From: Will Conway
Sent: Wednesday, February 21, 2018 3:56 PM
To: 'Jean Fraser'
Cc: 'Alexander M. Green'
Subject: Stormwater Comment Responses

Hello Jean, we have the following responses to the Wright Pierce Review Memo dated 2/7/18 :

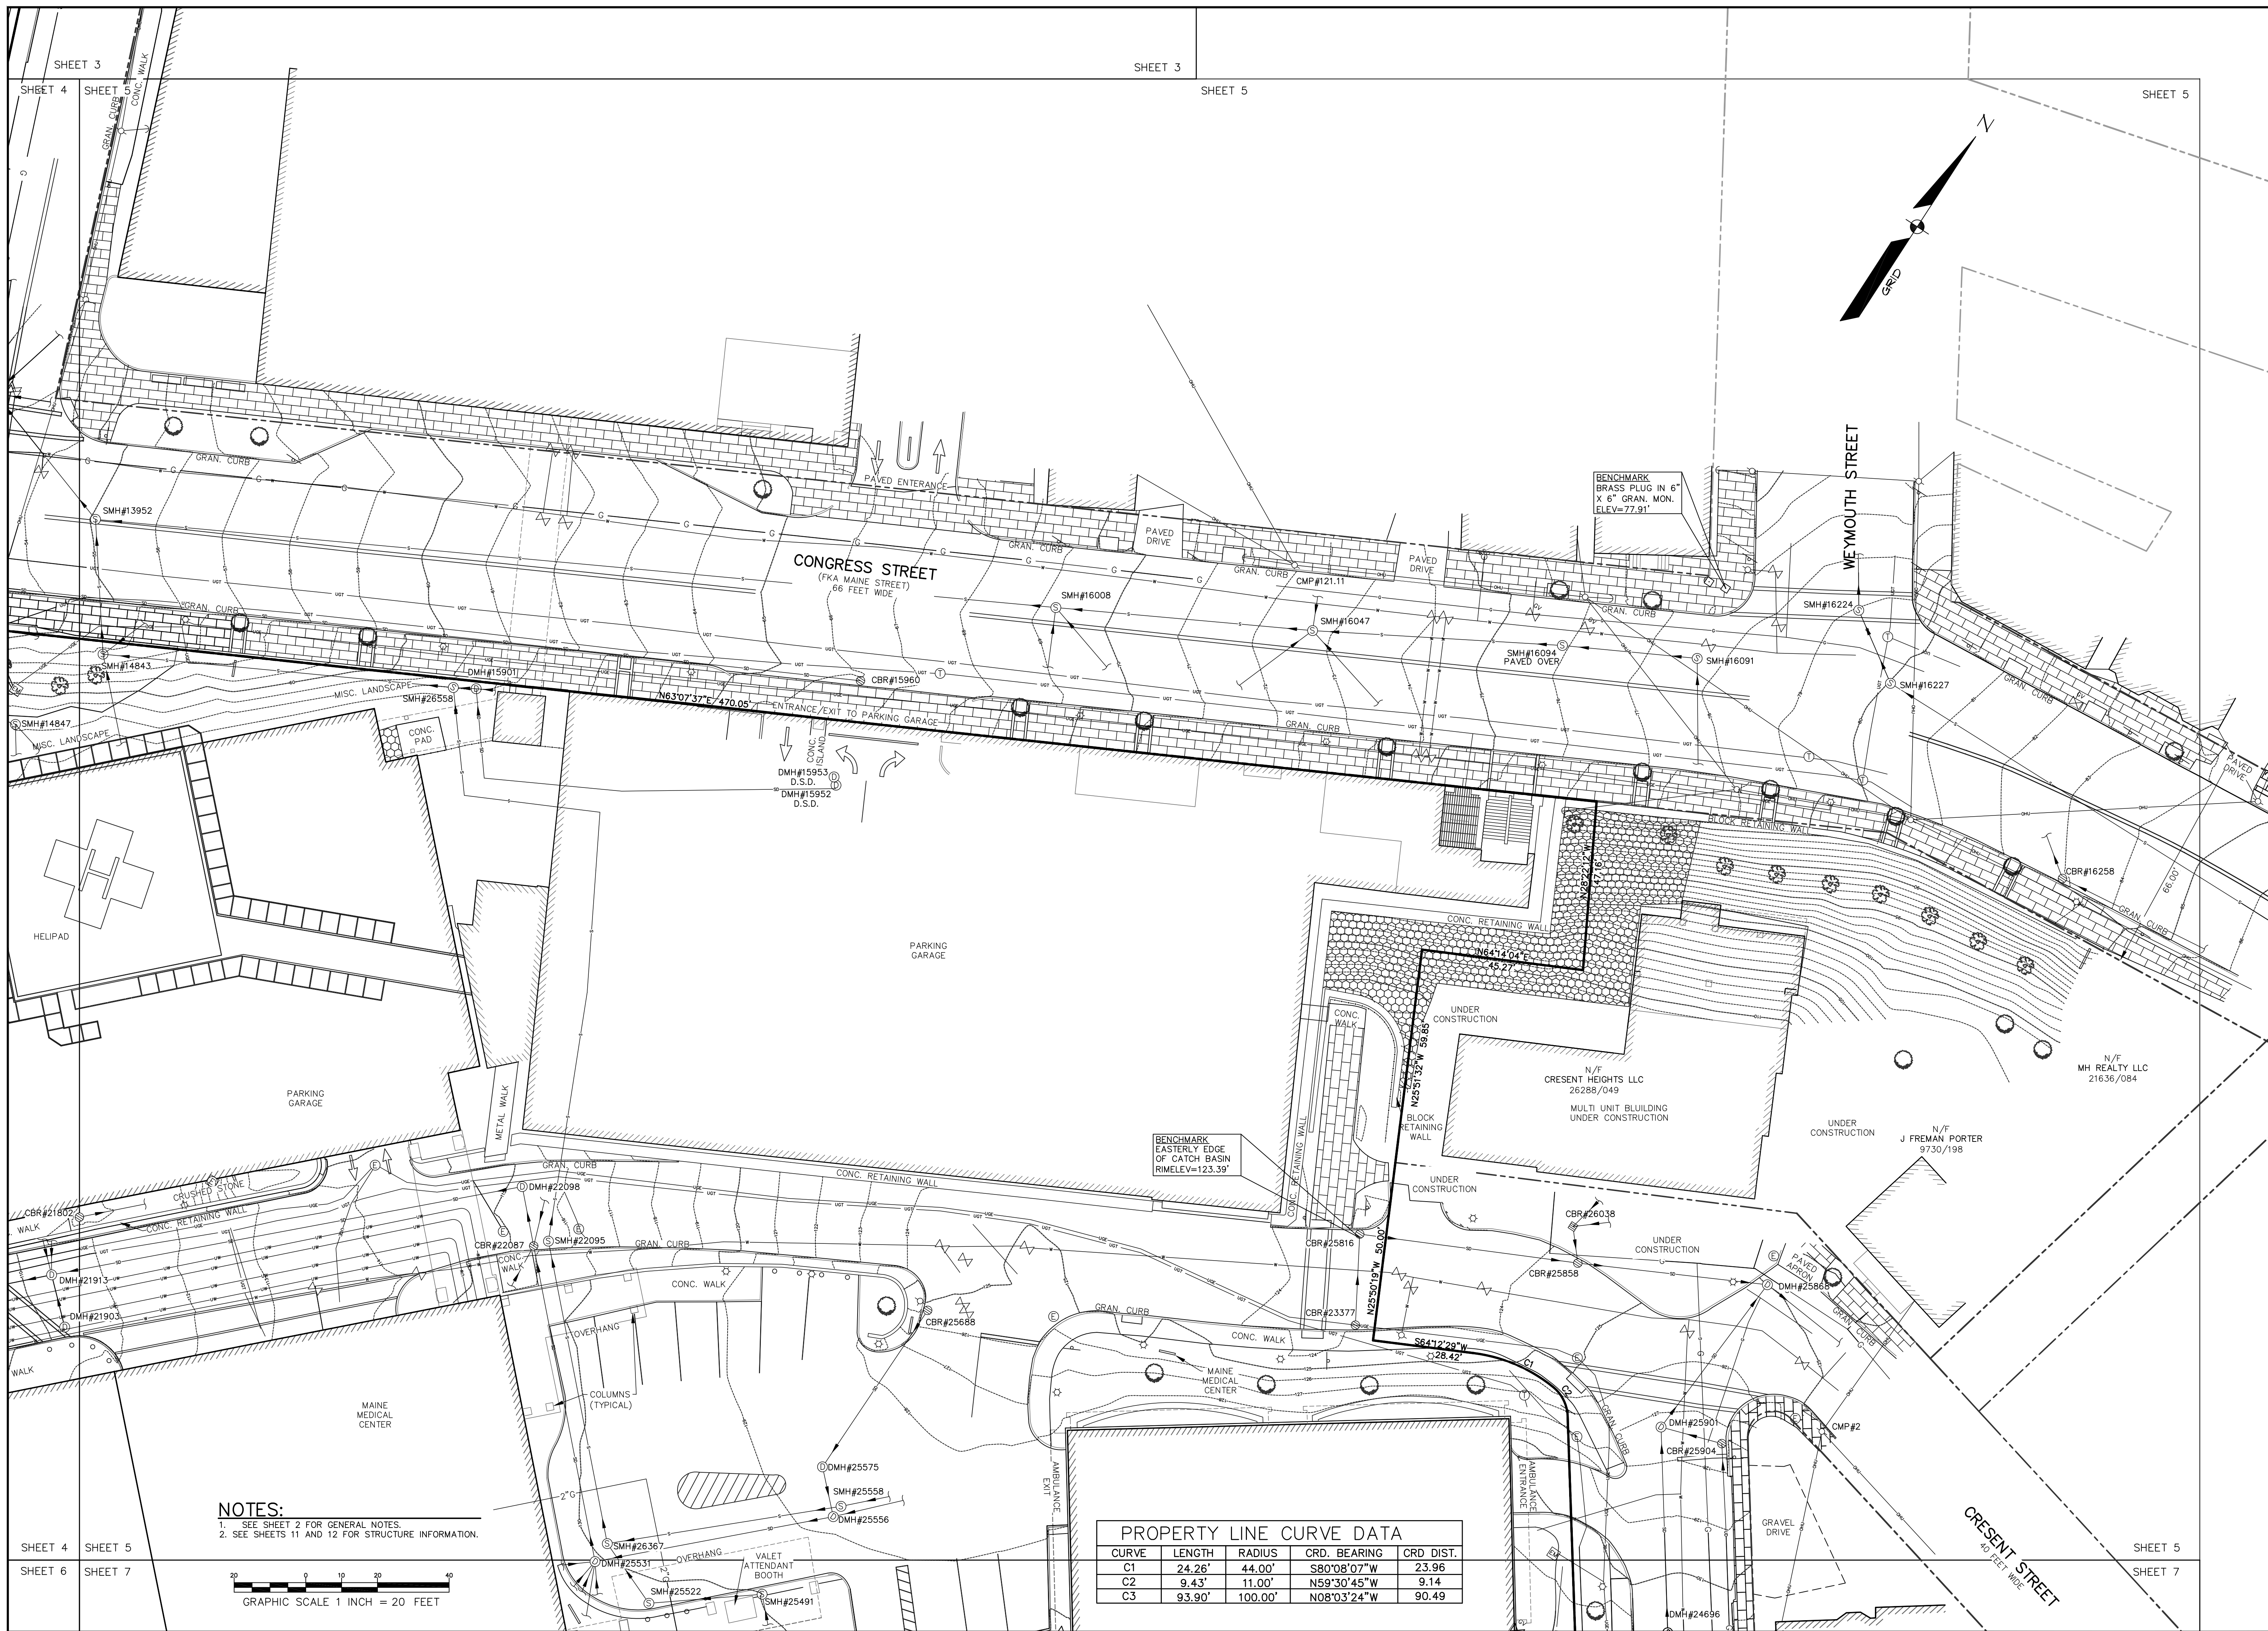
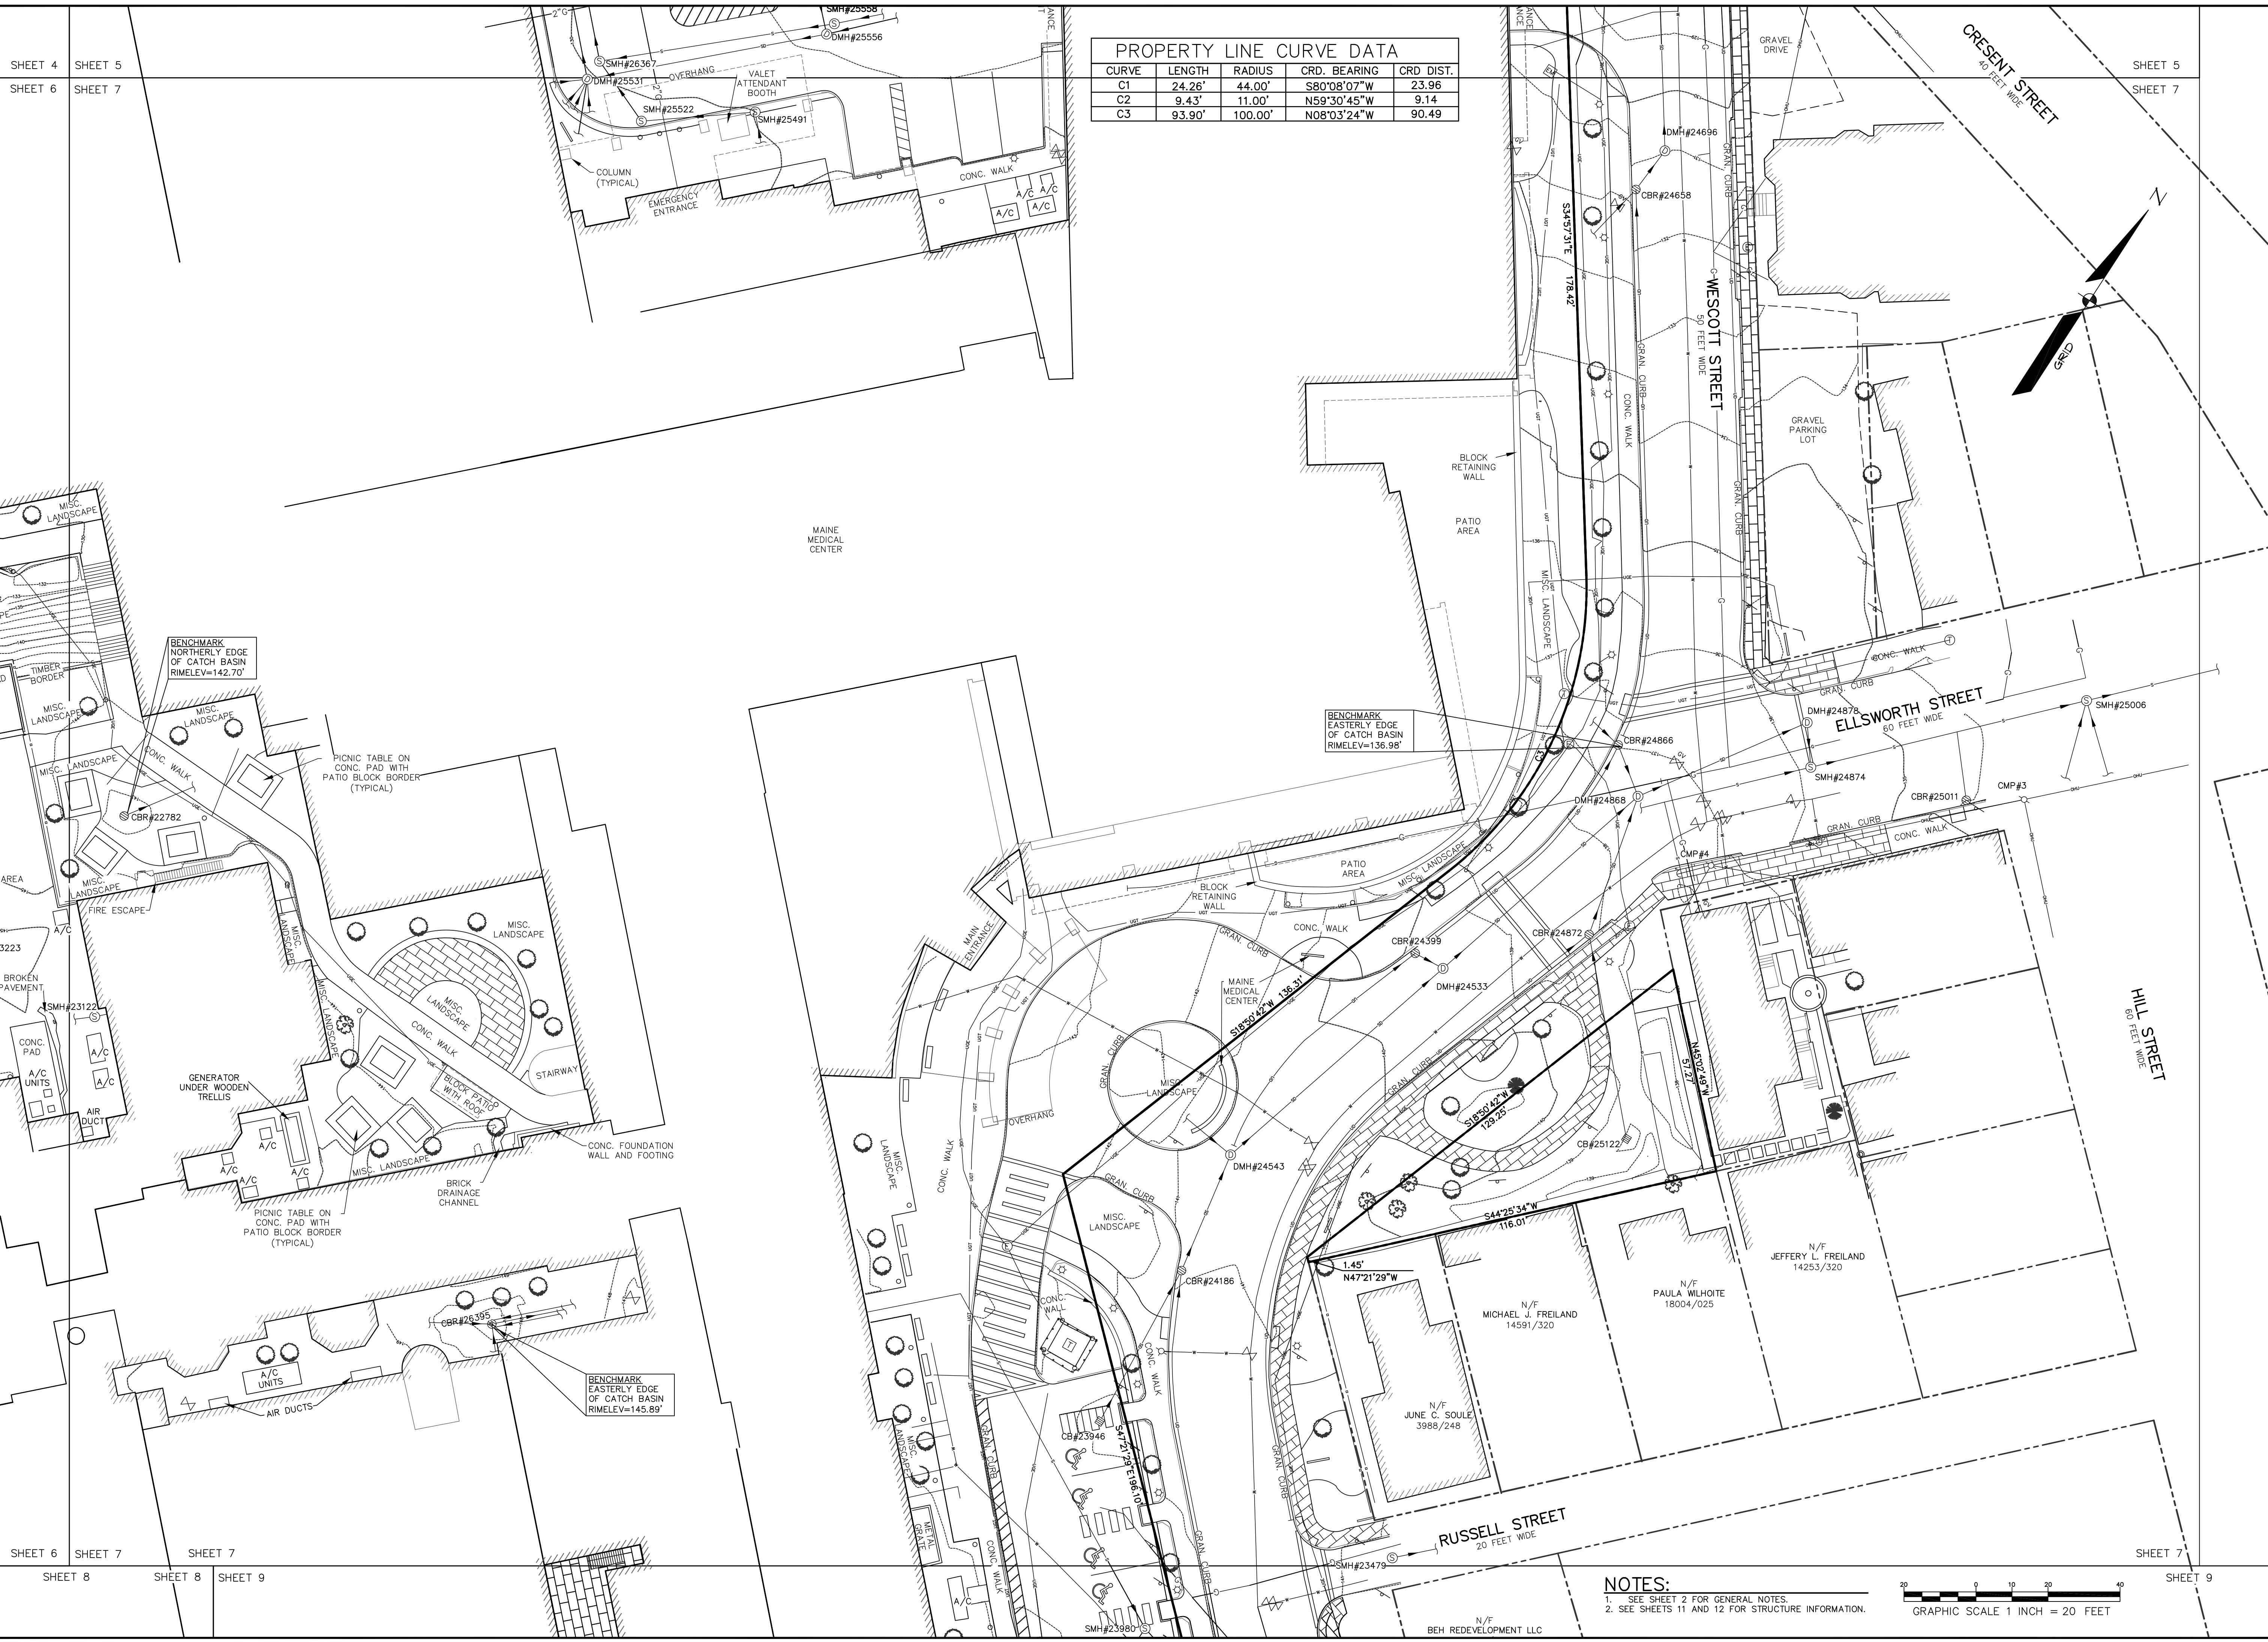
- Comment 1a – 1 c correctly state that Stormwater Basic, General and Flooding Standards do not apply to this project.
- Comment 3 (a) ii (1) requests that we submit an updated boundary survey with utility elevations, pipe sizes, and pipe materials added – that information is attached.
- Comment 3 (a) ii (2) AI will discuss this with Tuck.
- Comment 5(b) Regarding snow storage, MMC currently removes all snow from the site, and this will be the case in the future.

The updated boundary survey is saved in EPlan under plans / Plan2K Boundary Survey February 21
